Please find attached an amended drawing containing the changes that you have requested – (1) removing the rear projection so that the entire garden depth is 8.5m, (2) removing the rear dormer window to Bedroom 1 replaced with 2no. roof-lights at 1.5m height in order to ensure no possibility of overlooking, and (3) and very modestly enlarging the front elevation in line with your comment.

Heathers Arundel Road Angmering BN16 4LE

Job No	Drawing No	Rev
LGC Bungalow	001	P3

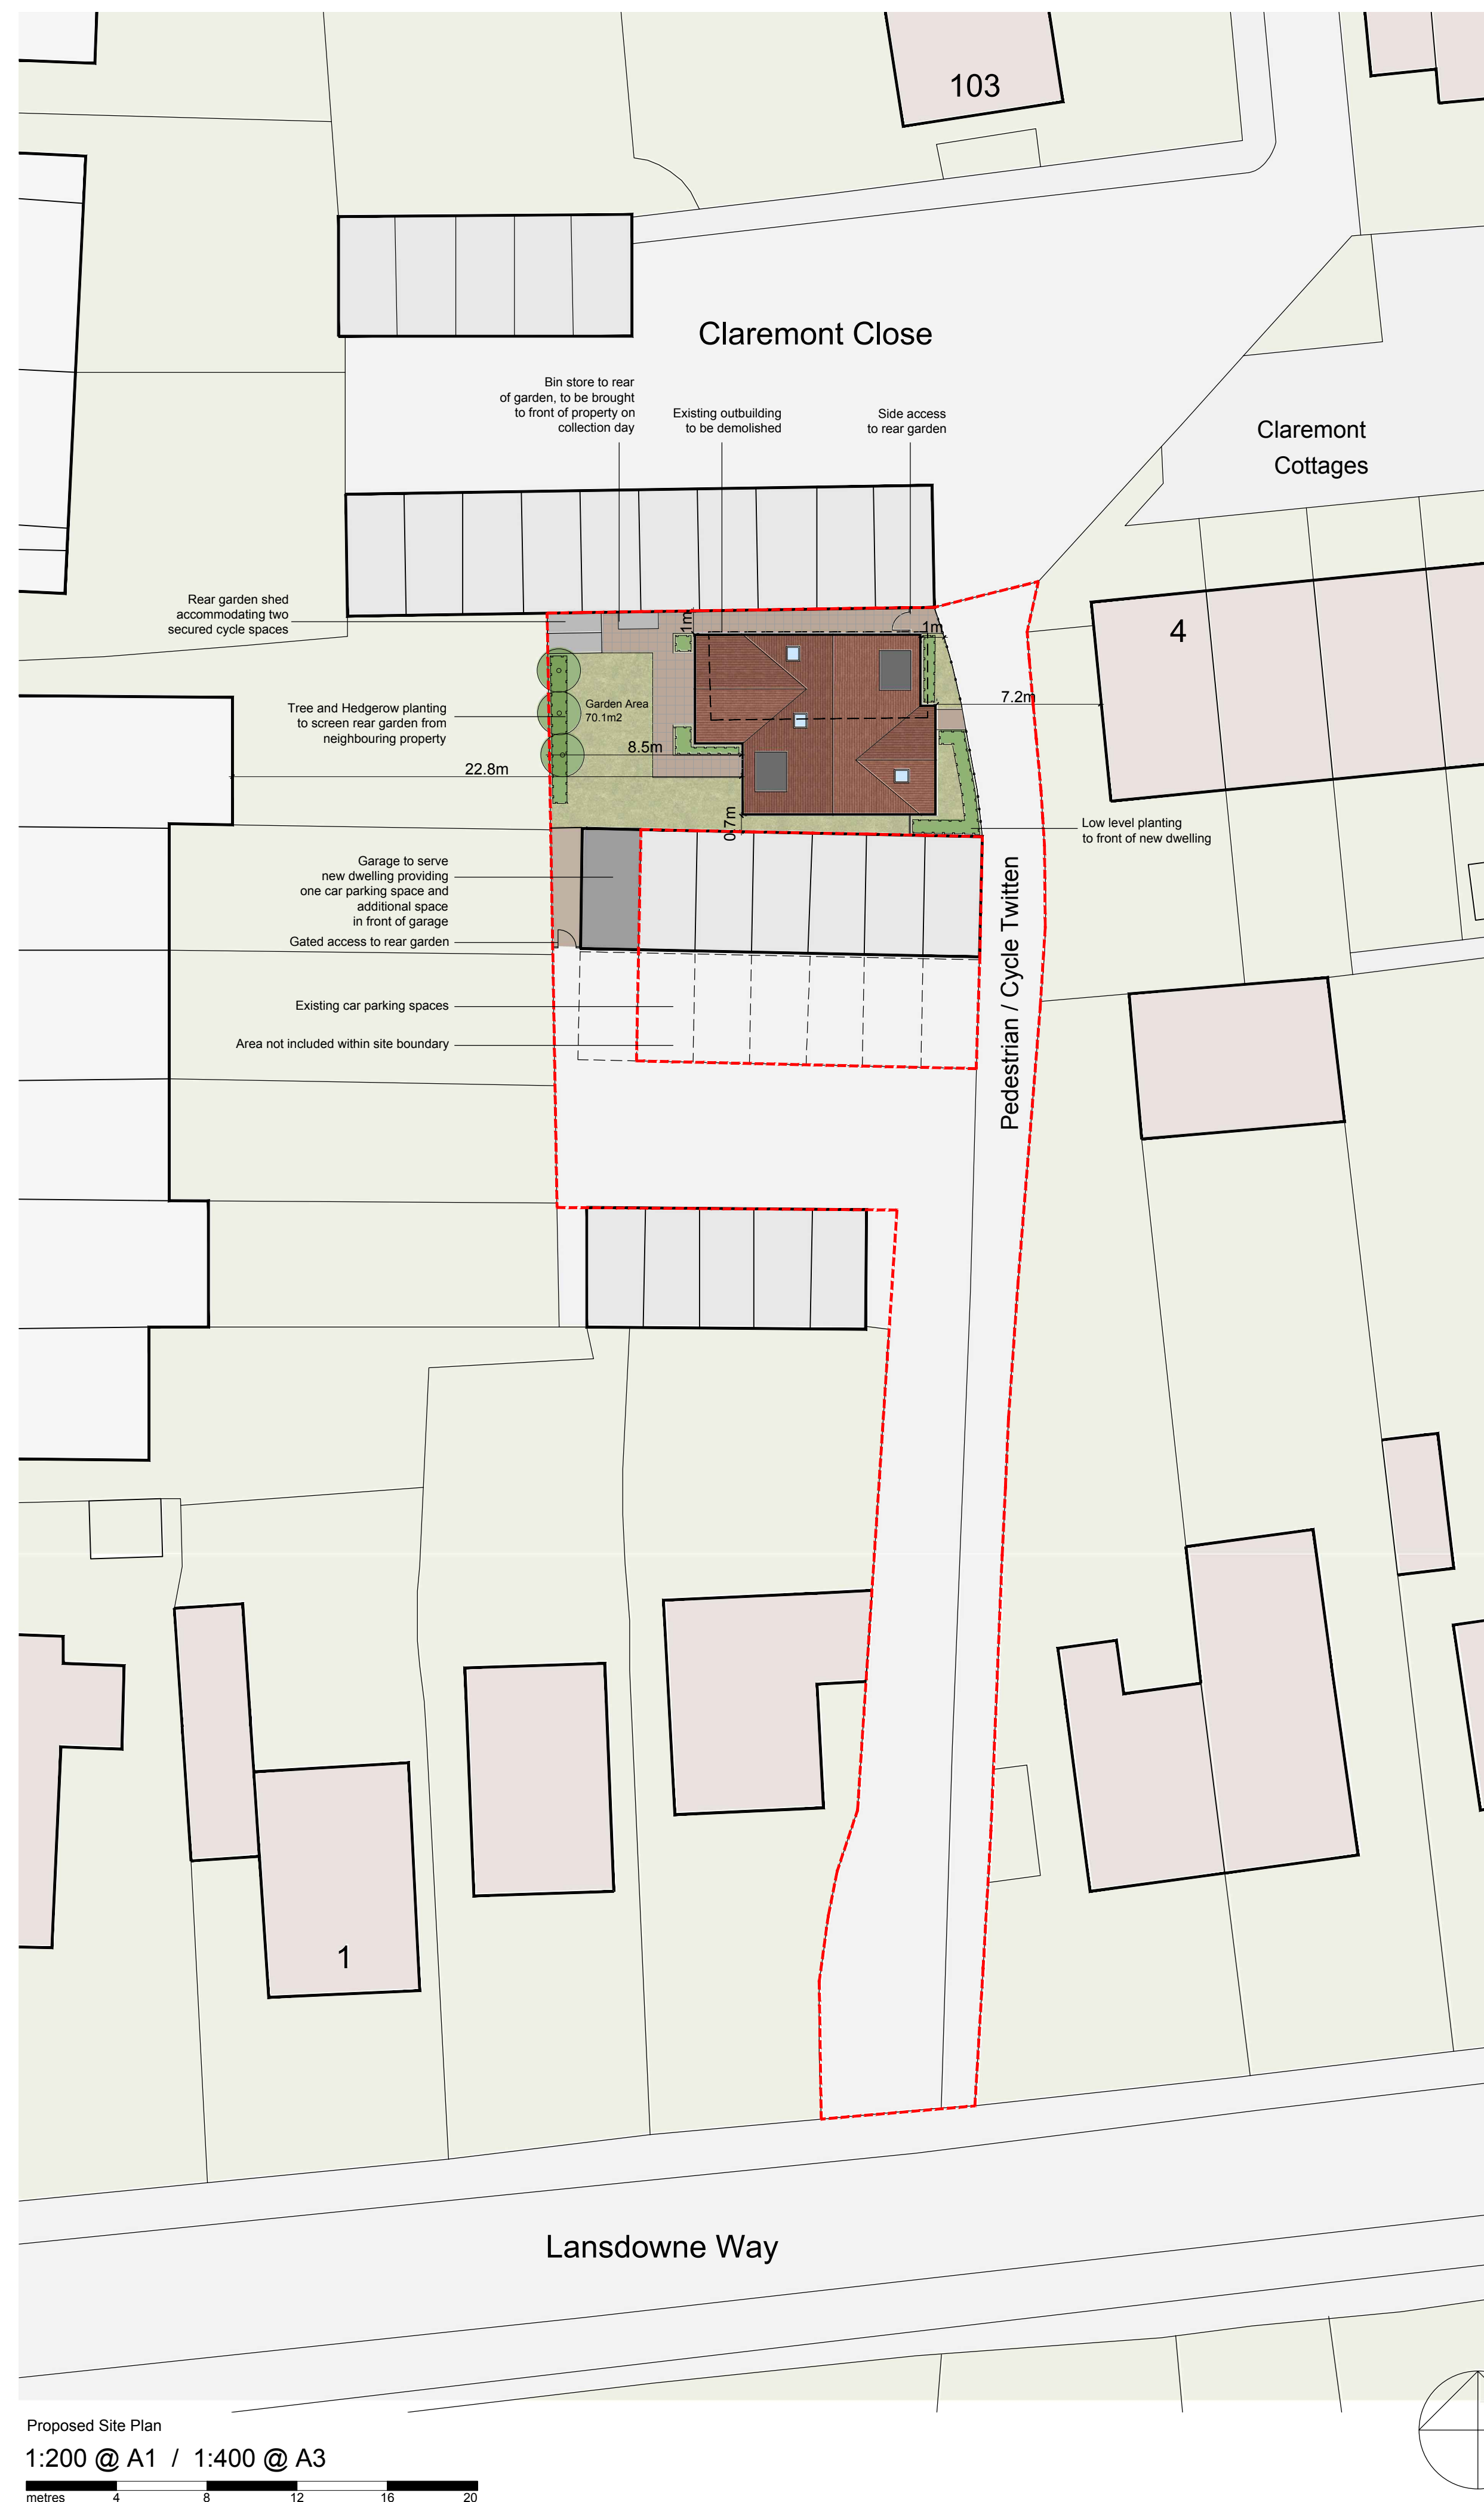
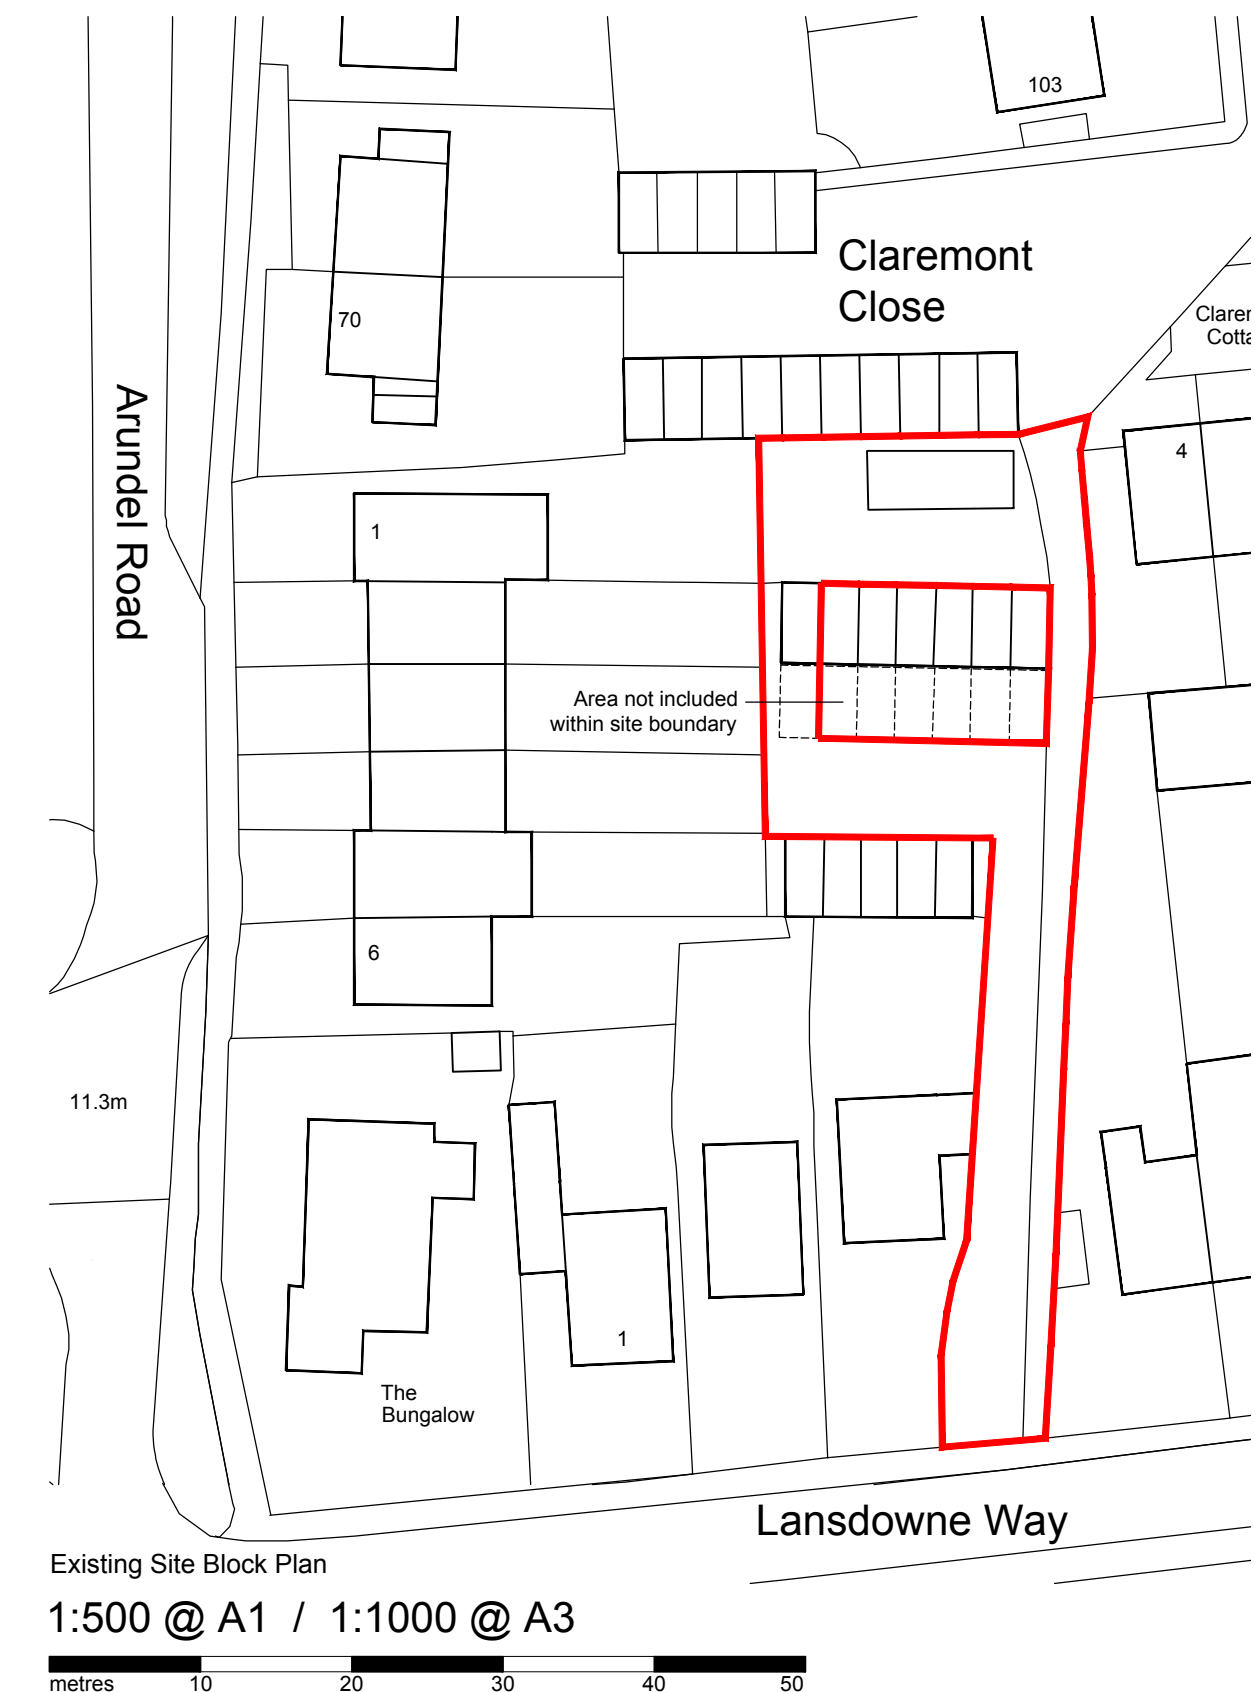
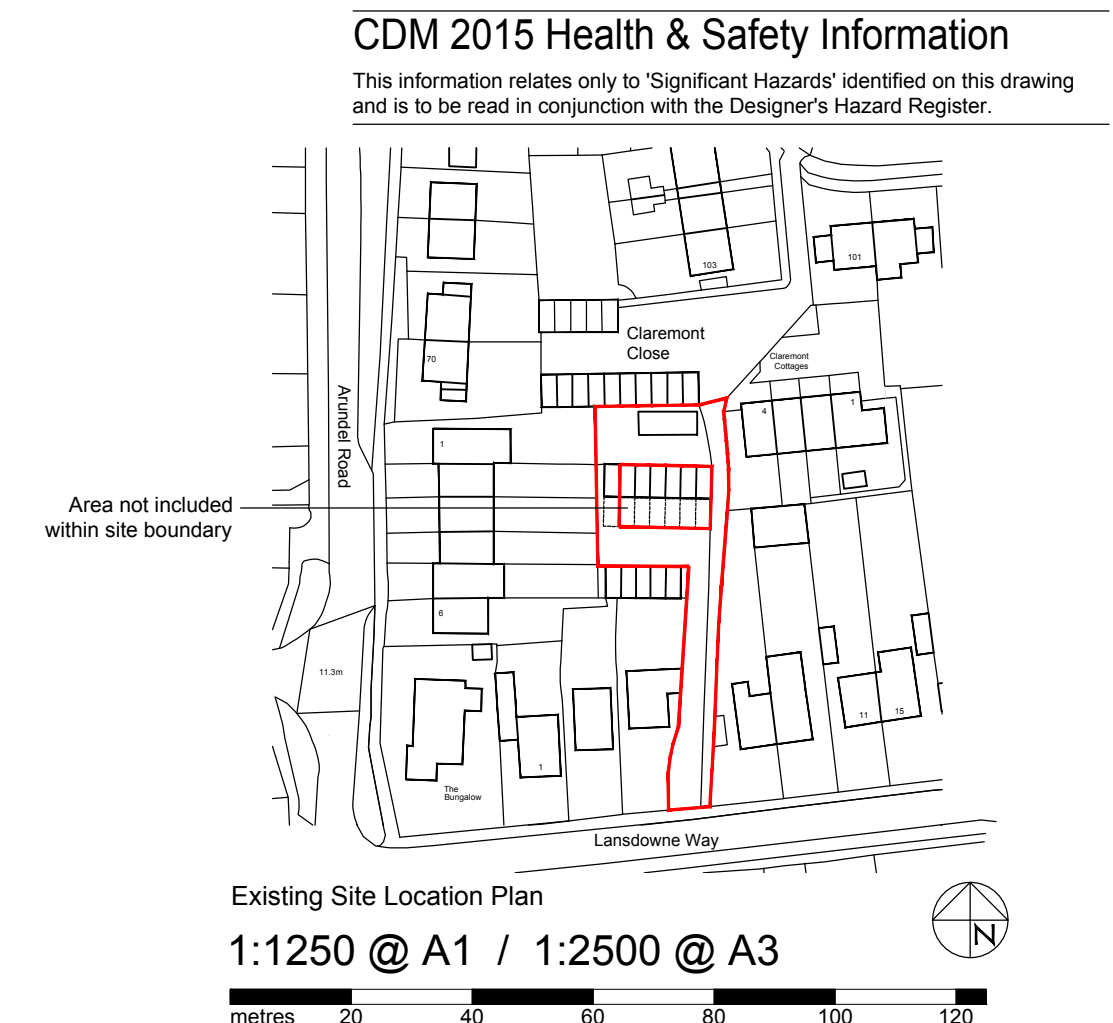
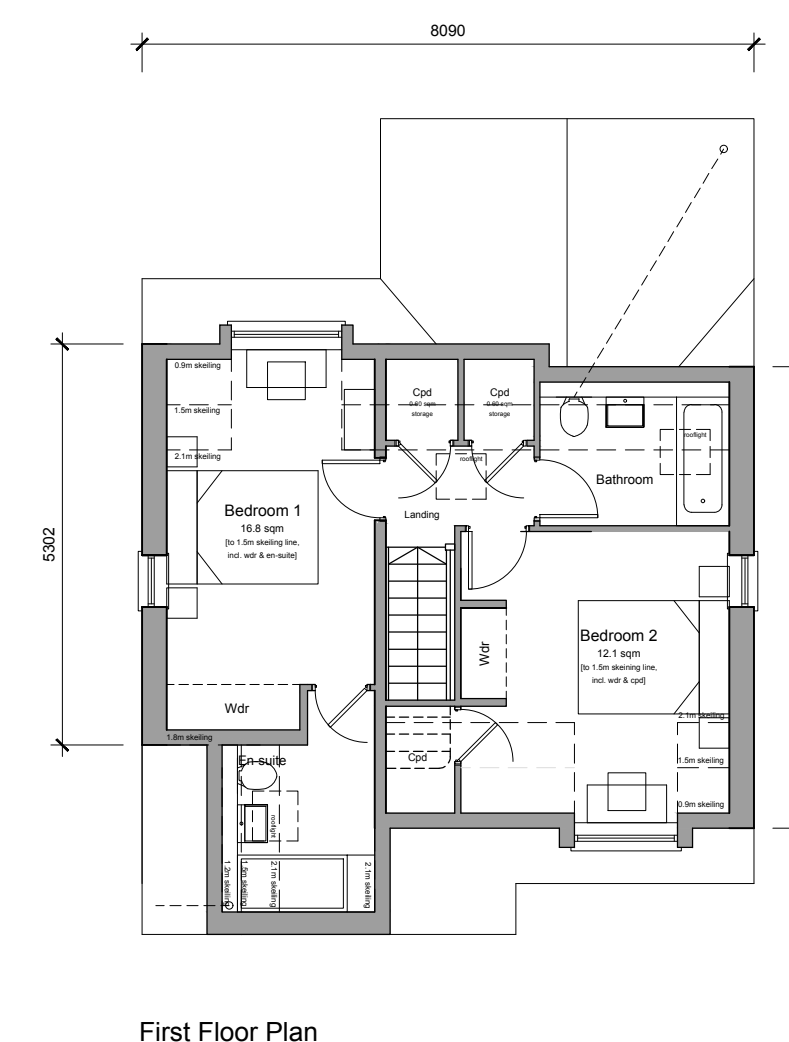
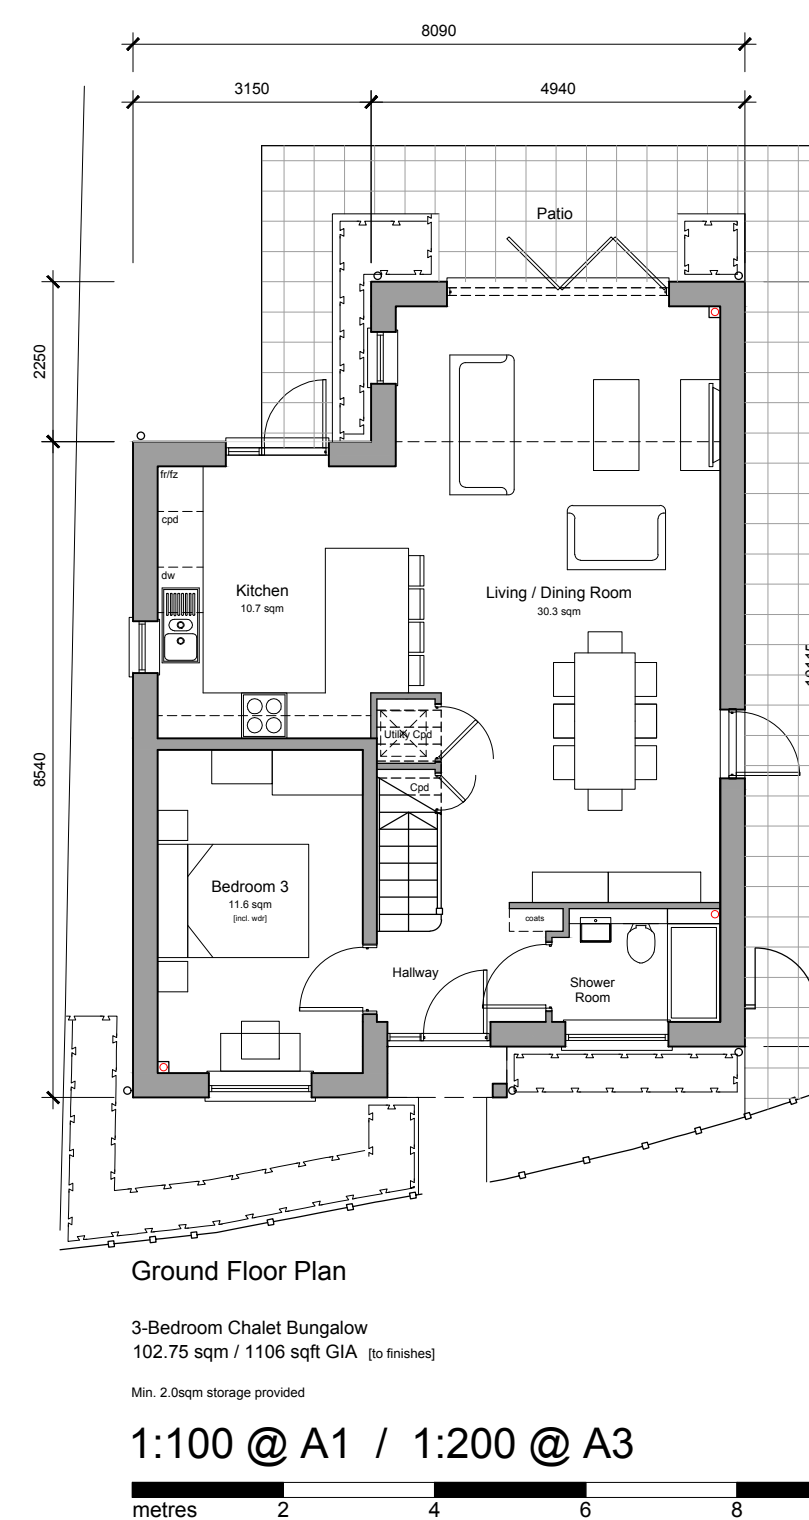
I had a chat here internally and we feel the proposal could be ok, on balance once a few changes are made. I mentioned your willingness to make whatever changes we felt necessary to get it over the line. Could you send in an amended plan removing the rear dormer (replacing it with a rooflight) and squaring off the rear elevation so that the rear garden depth would now be 8.5? If you wish you could slightly enlarge the dwelling at the front elevation to get back some internal space.

A rear garden of 8.5m in depth at maximum and 6.3m for the majority is less than what's recommended. As I'm sure you know 10 or 11m is looked at as a minimum depth. Although the principle of development is ok other issues such as above and the hemmed in nature of the proposal in relation to the rows of garages on either side are likely to be other issues for this proposal. I will have a closer look at 'Red Admiral Bungalows' and if possible visit this site when on site next week.

Your suggestion and willingness to make further amendments to the proposal in terms of the rear gable end and rear facing dormer window are also noted. However before I ask you to make any amendments I would like to carry out that site visit to see if this is what's needed to bring the proposal to a positive conclusion.

A point made in one of the letters was that there is a 1.5m drop from one end of the site to the other. If so a skyline plan showing how the proposed would look in relation to other nearby dwellings/ bldgs. would be helpful.

We will provide an updated drawing showing the amendments to the garage to turn it into a car port, so will send this over soon.

In this regard, we do have the option (whilst I do not believe it to be at all necessary due to the separation distances involved and the chalet nature of the property), to amend the ground floor gable window to a standard door/window set, removing

the triangular glazing, and also to amend the dormer window to Bedroom 1 and replace this with a roof-light if you consider these as requirements to secure a positive recommendation.
